Landscape Review

of the **M3 Junction 9 Improvement**

Prepared for
South Downs National Park Authority

PINS Reference
TR010055

DRAWING TITLE
FIGURE 7.3.1 - LANDSCAPE AND VISUAL: LANDSCAPE CHARACTER AREAS APFP REGULATIONS 5(2)(a) DOCUMENT REFERENCE 6.2

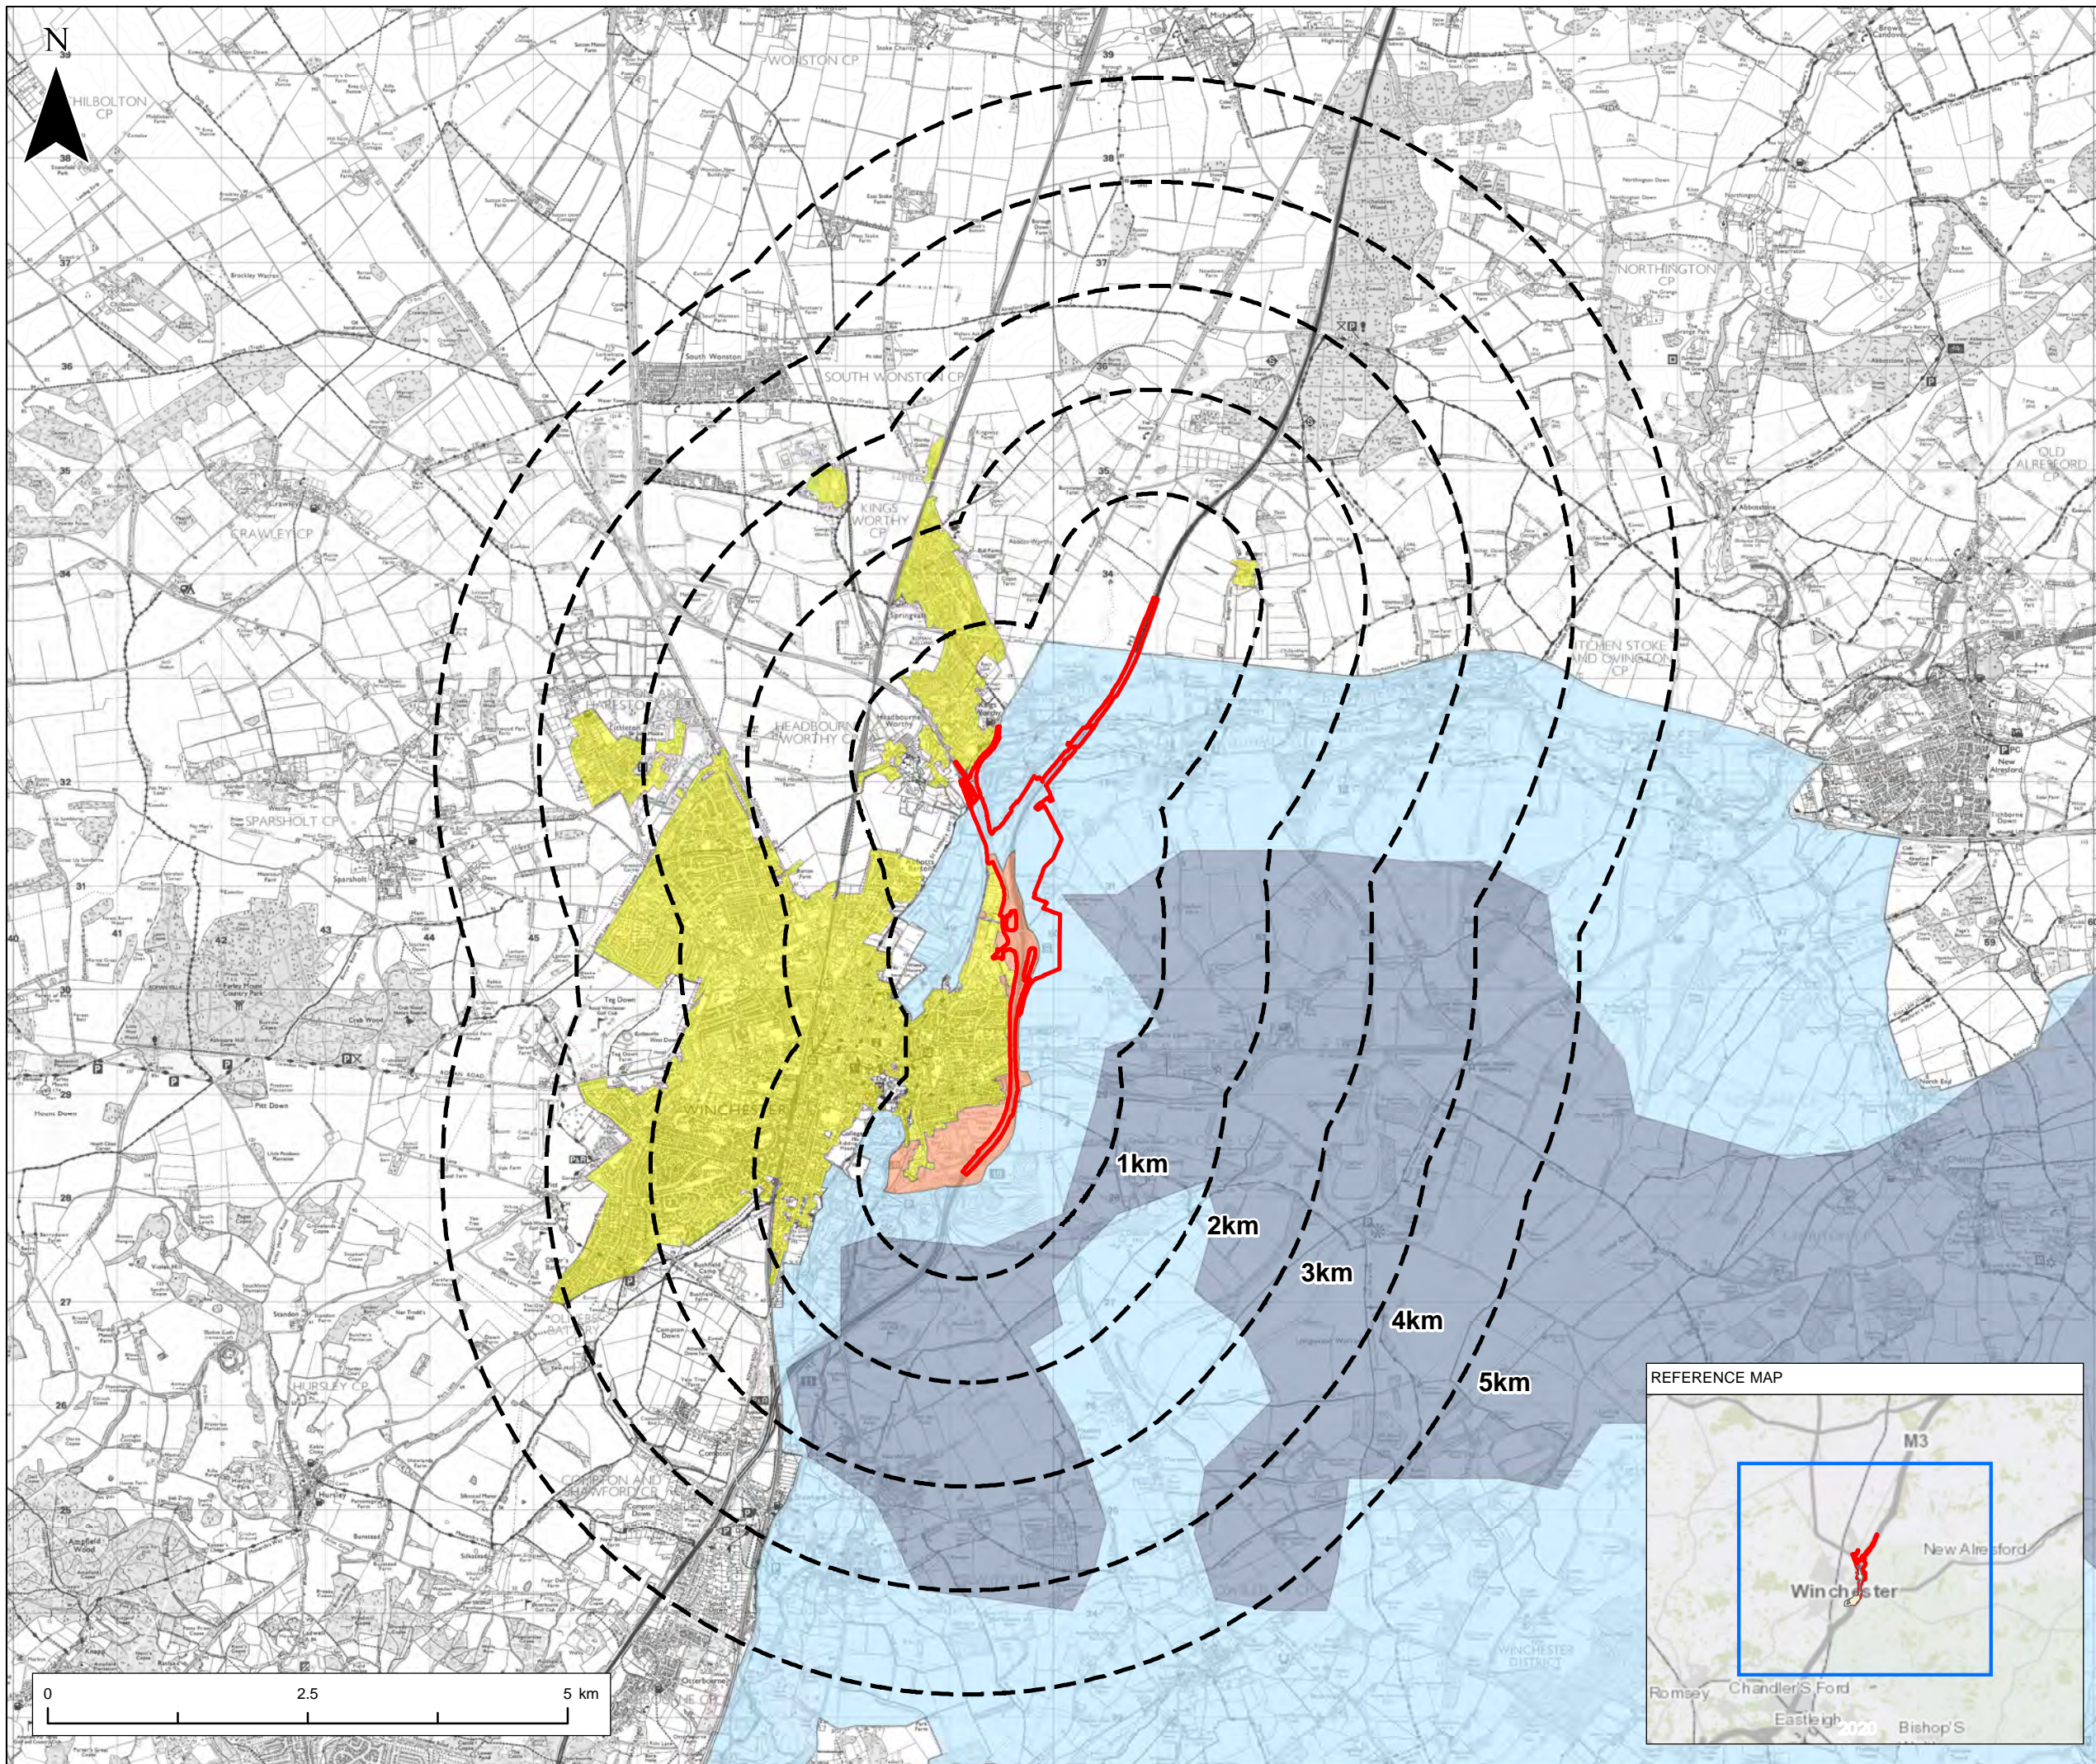
4.81.9 ~~This range of landscape character is reflected in~~The South Downs Landscape Character Assessment, September 2020 ~~which~~ identifies parts of three different landscape character areas (LCA) within the site (**Figure 4**). ~~These LCAs are~~:

4.101.11 ~~The most relevant~~ Landscape sensitivities relevant to the application ~~are those described in~~ relation to LCA A5 East Winchester Open Downland, ~~which~~ are:

**FIGURE 7.14 LANDSCAPE AND VISUAL:VISUALISATIONS - SHEET 26 OF 28**

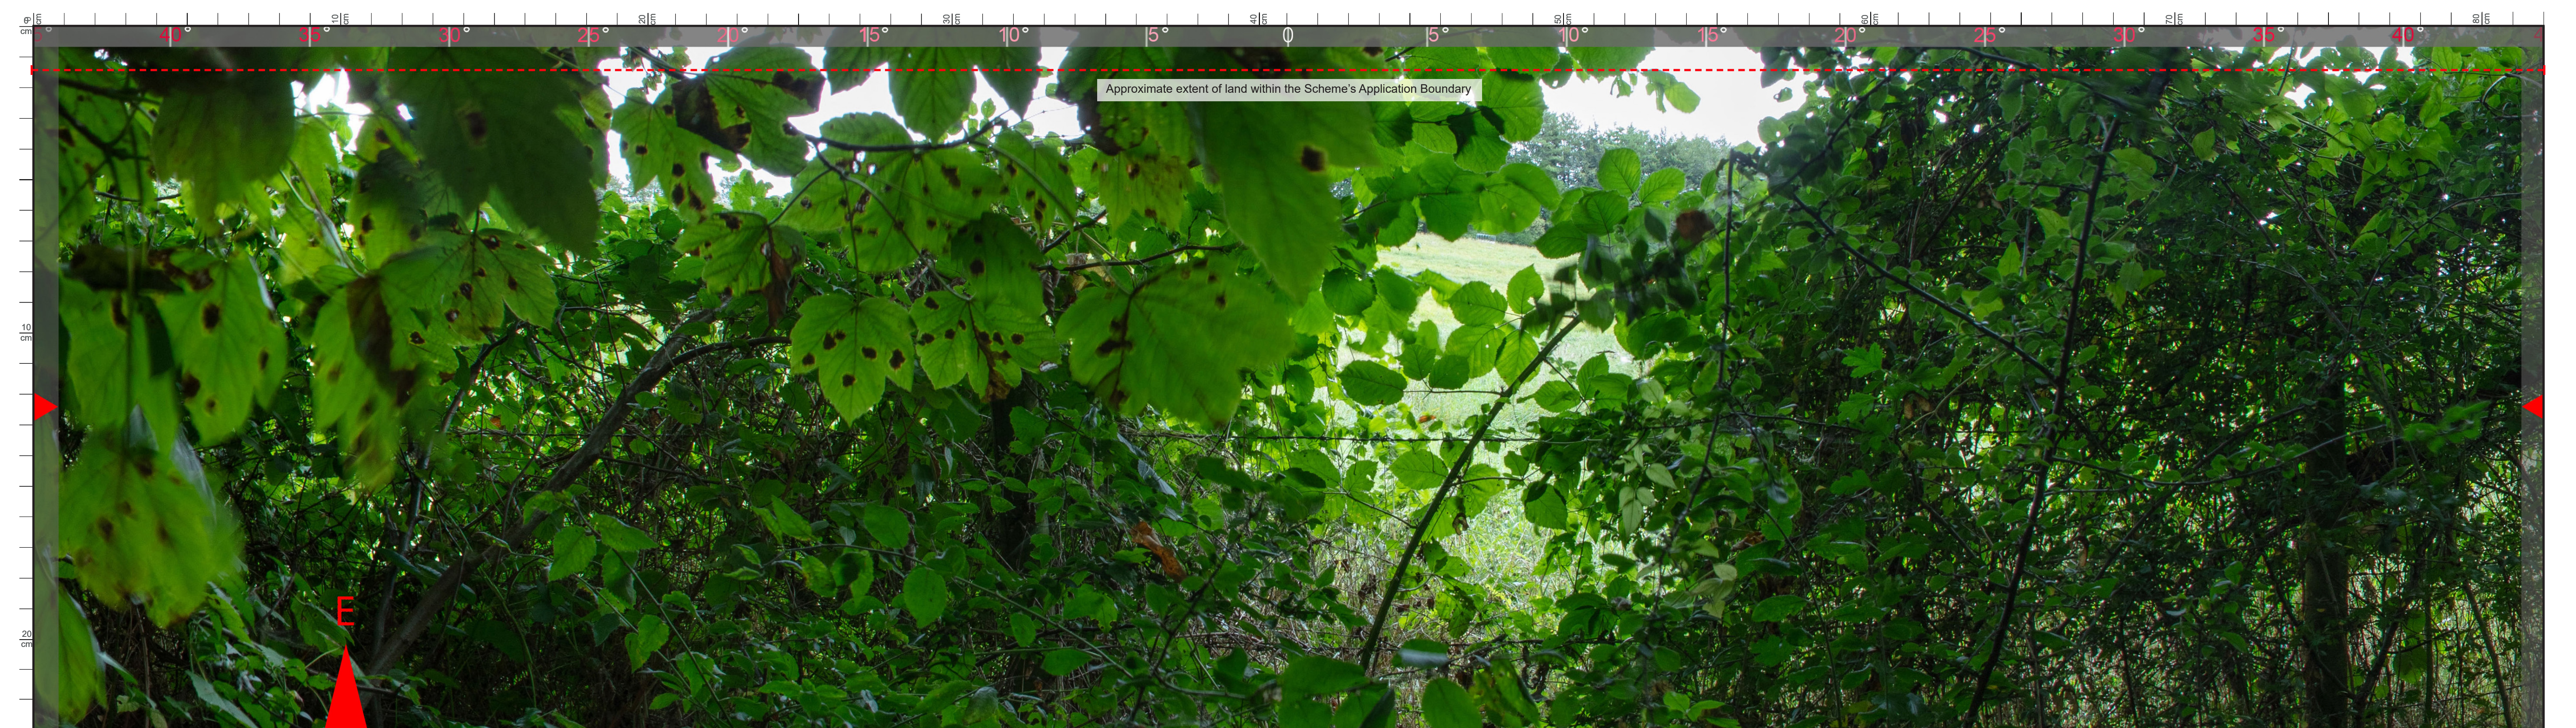
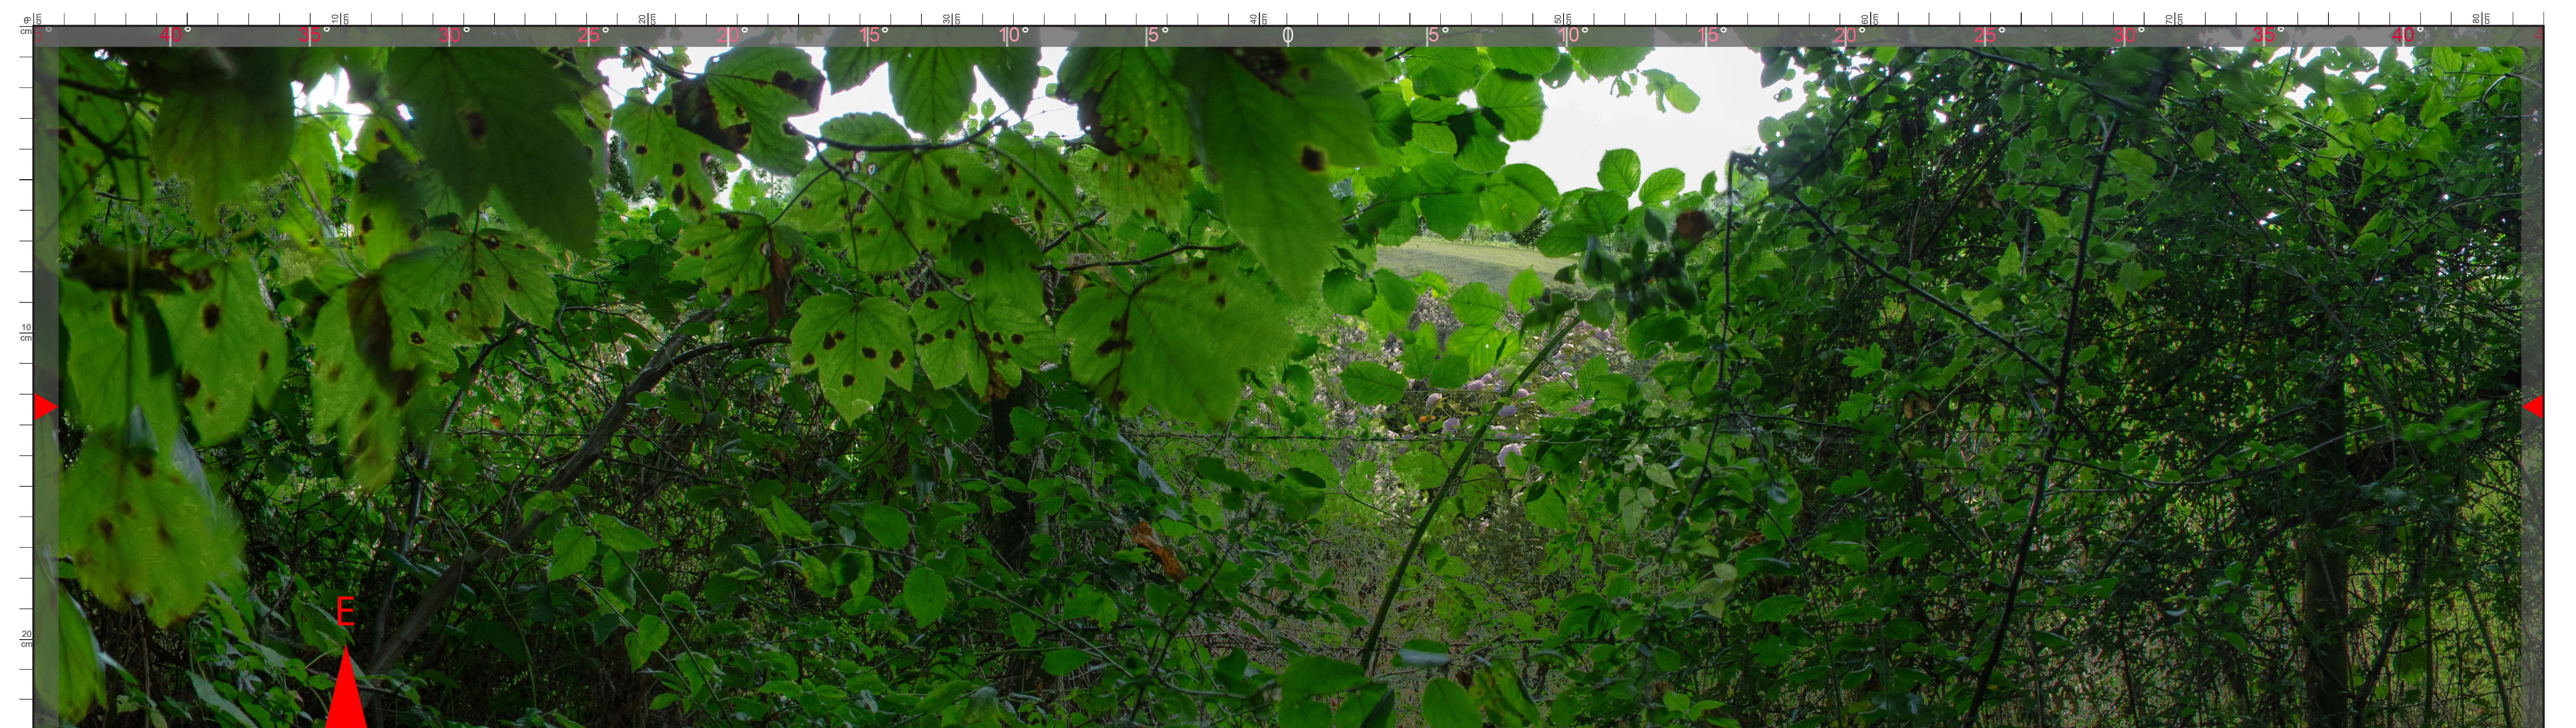
- 1.19 The effects have been underestimated in the LVIA chapter and they are also underestimated in the accompanying visualisations submitted by NH ~~because~~ which form part of that assessment. The visualisations fail to accurately show the loss of vegetation. We identified that this was the case for Vp 14 and the revised Vp 14 submitted at Deadline 1 (REP1-010⁷) has confirmed that the tree removal had not been shown. We have now reviewed the other visualisations and there is a more significant failure to show tree loss from Vp 3 and Vp 7. NH have said that they are reviewing the visualisations and will submit new visualisations for Deadline 3.

- 1.20 In addition to the failure to show tree removal the visualisations do not show the full impact of the proposed works. ~~For the benefit of the upcoming Examination, it is recommended that issues raised~~For example, the slip road in this review are addressedVp 14 has the appearance of a cycle path rather than a major element of a motorway with all the attendant road markings, signage, traffic etc..
